Sent: 16 January 2013 14:43
To: Planning
Subject: Planning application S6/2012/2608/MA
Attachments: andrew.vcf

Case Number 2608
Alt Ref S6/2012/2608/MA

I am the owner of Nyn Manor which adjoins the boundary of Nyn park Estate which the planning application relates.

Deer fencing - Elevation

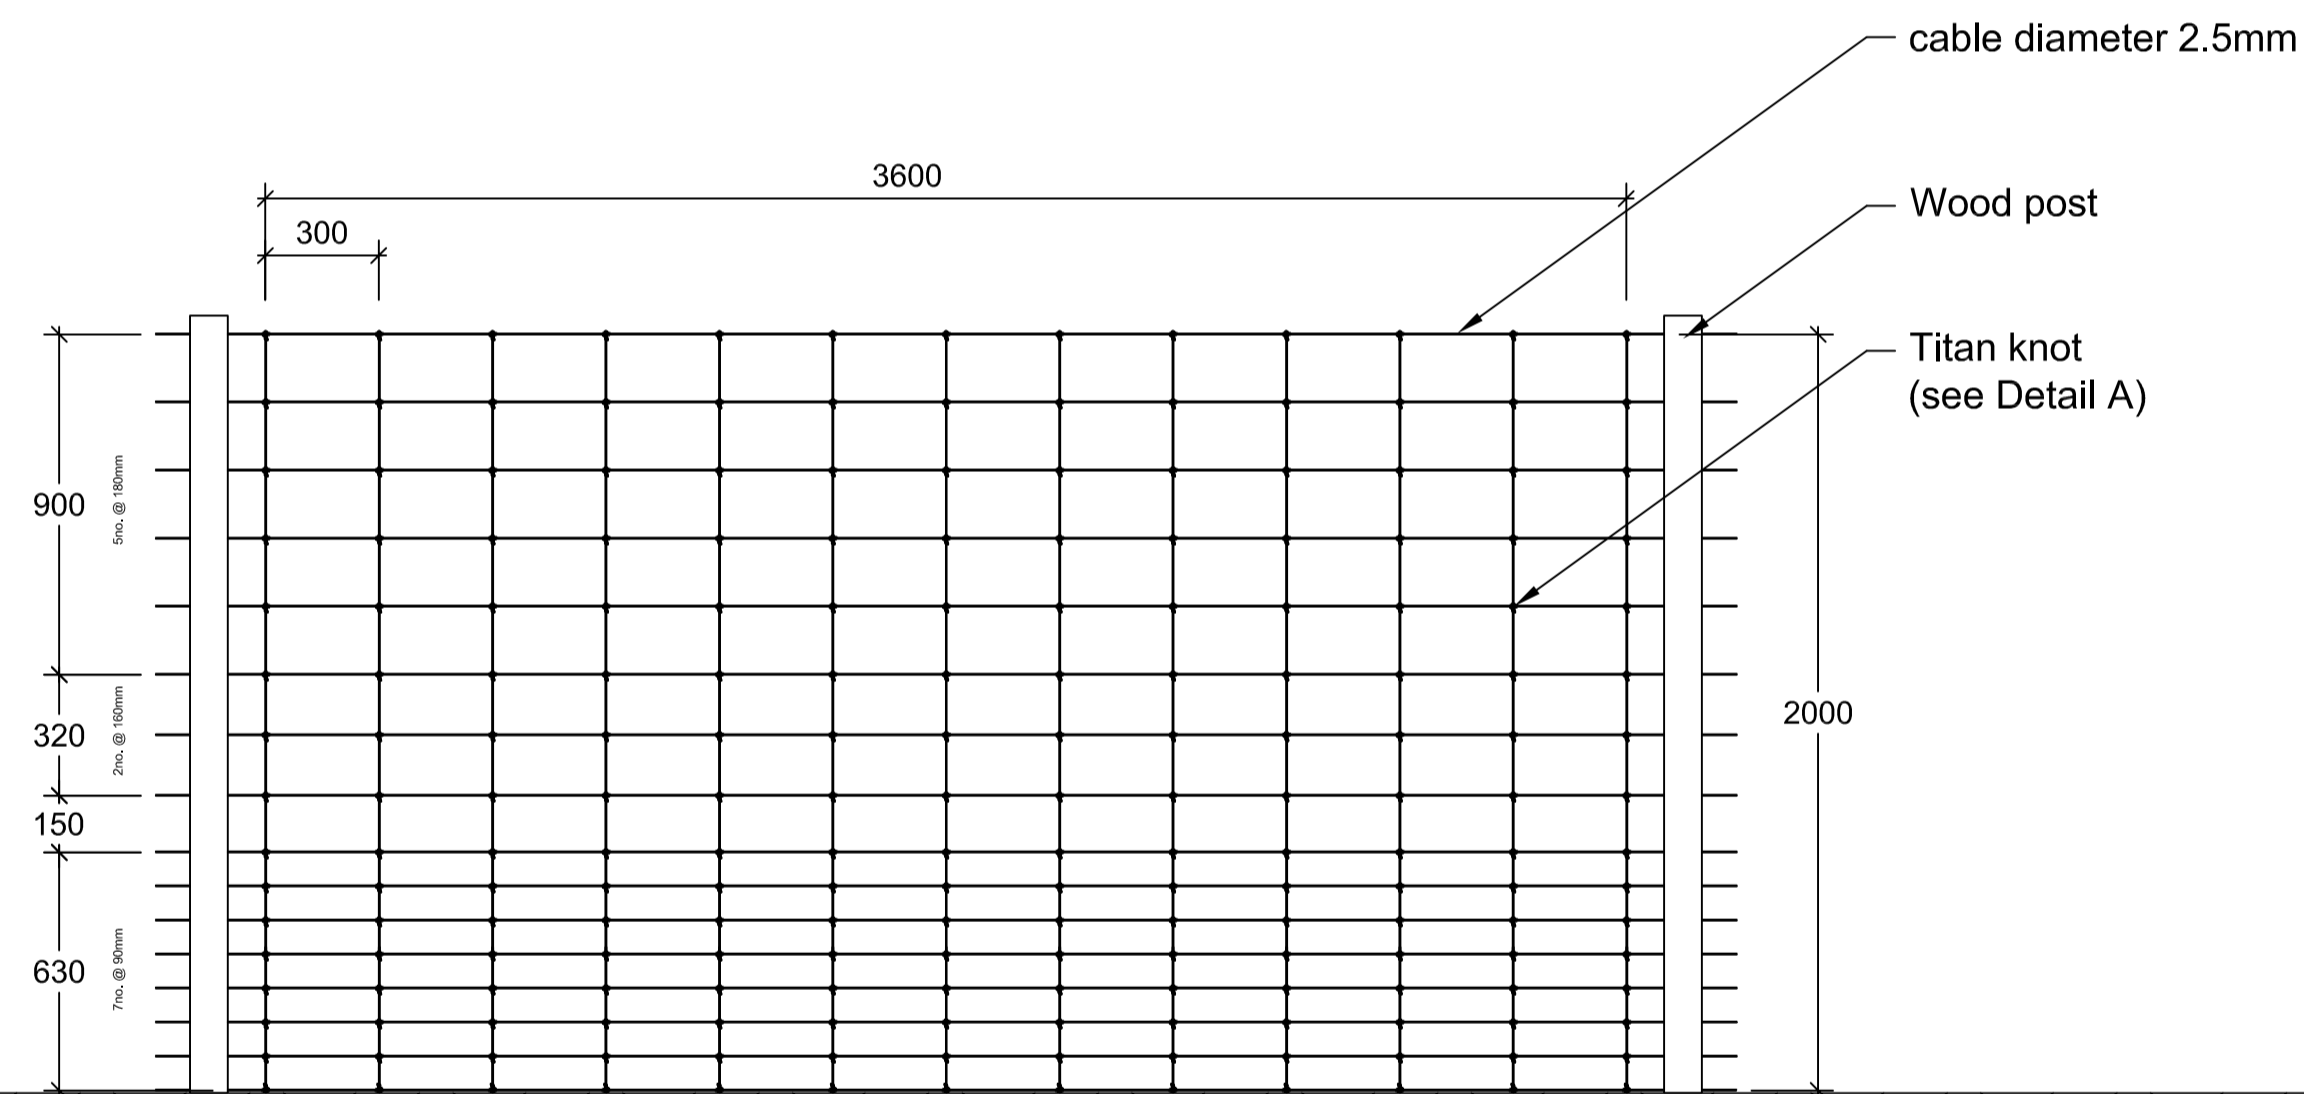
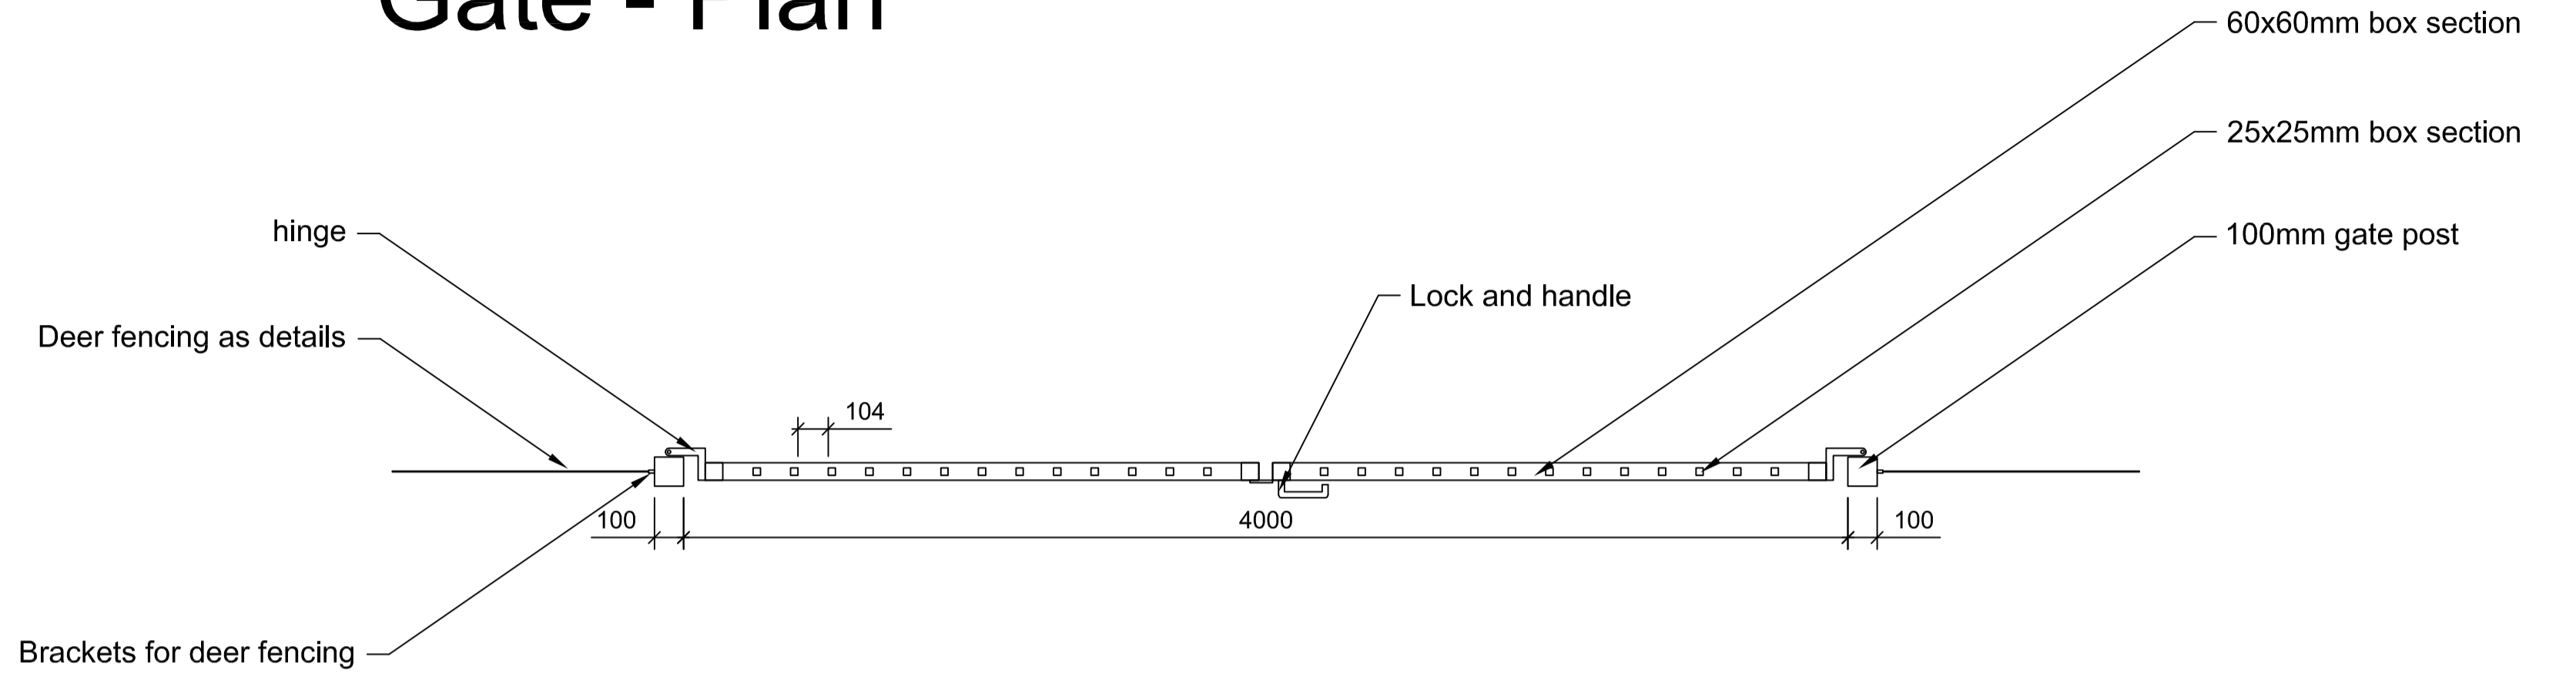
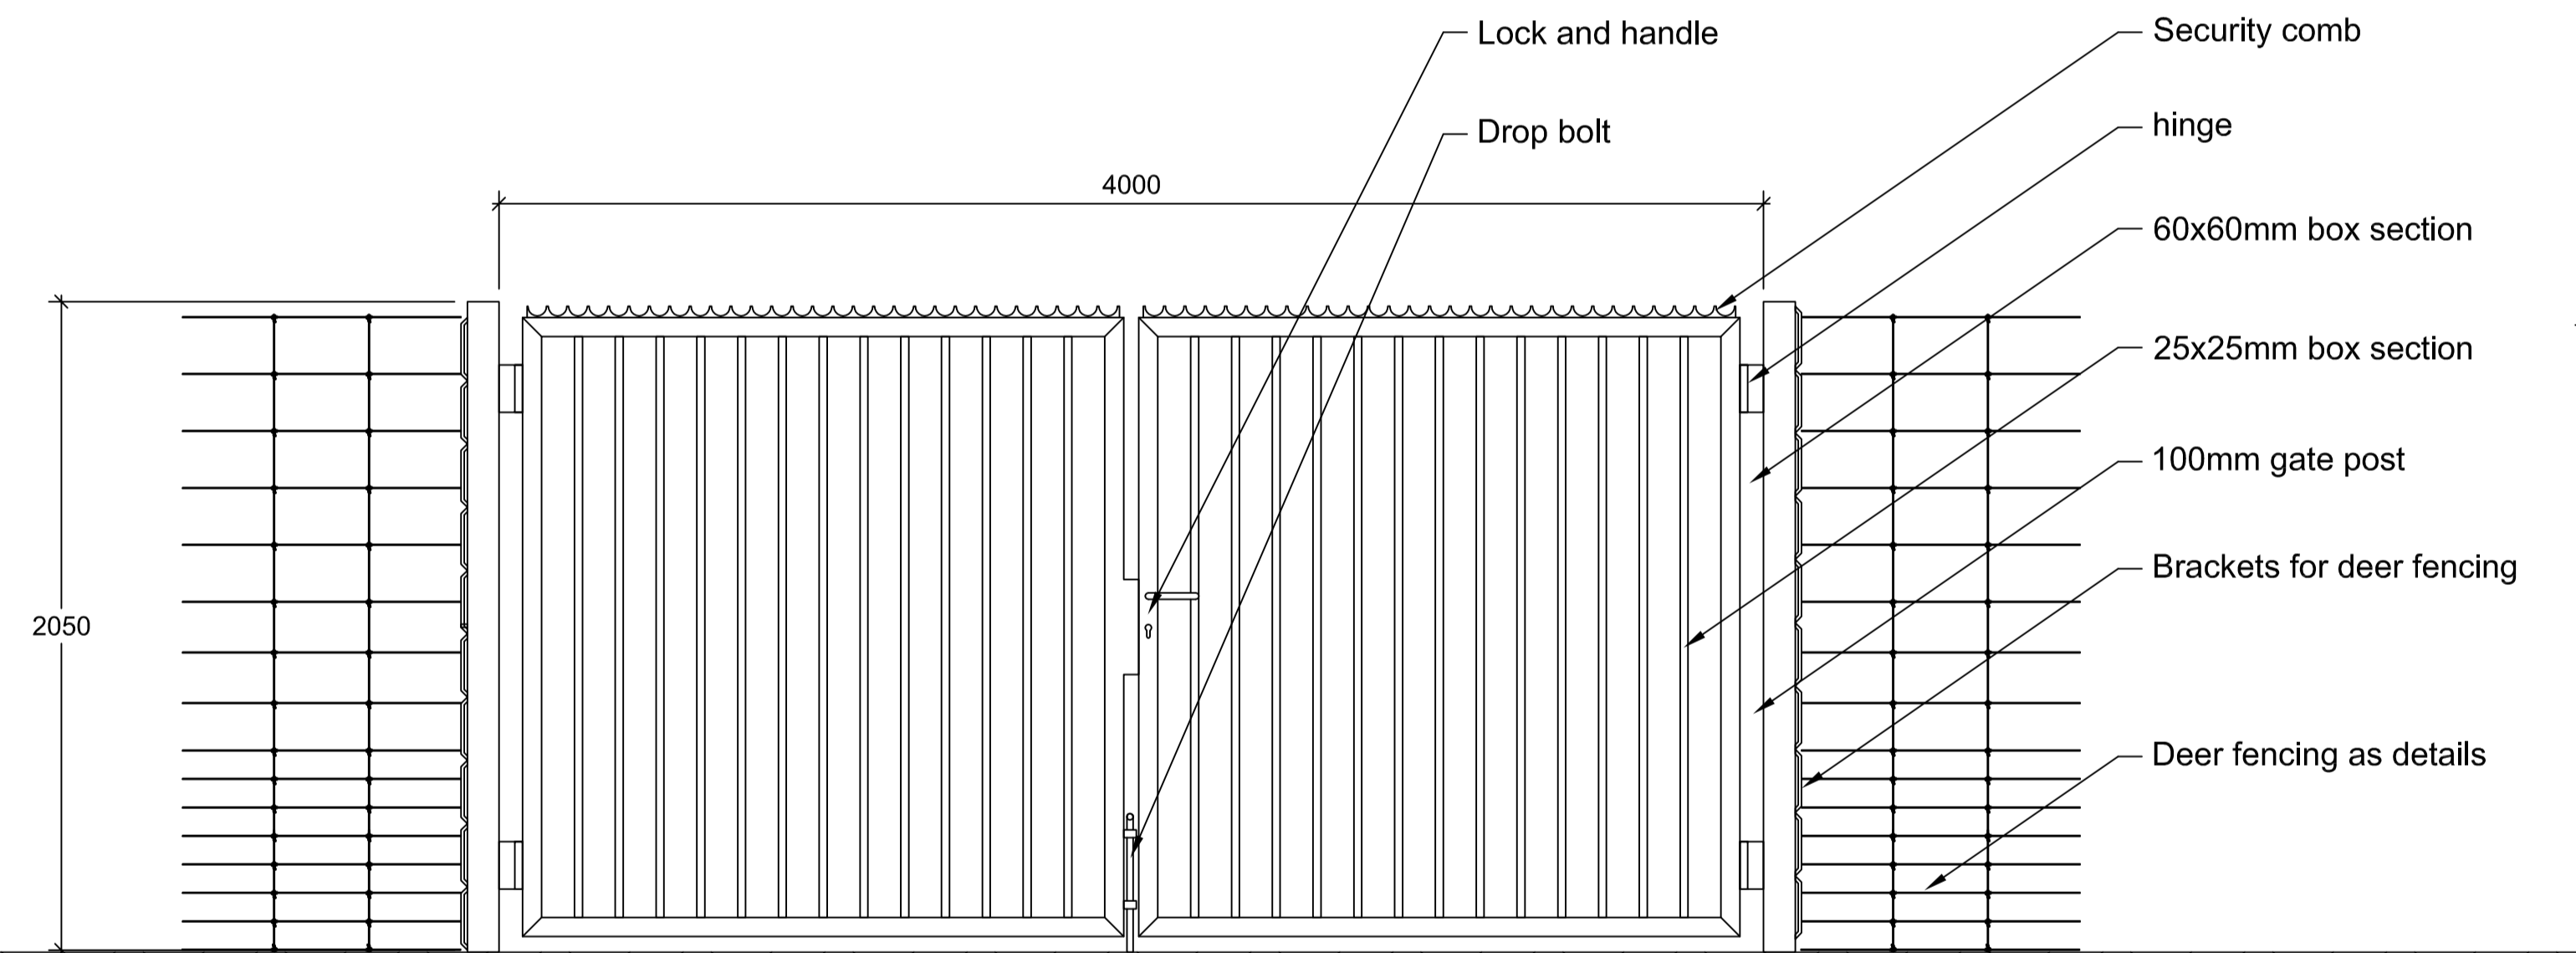
I have concerns that the type of fencing proposed will preclude and prevent access for ALL wildlife which would be unacceptable. The ecology could/would be affected.

Could a different type of mesh be used to allow animals to cross (both ways)
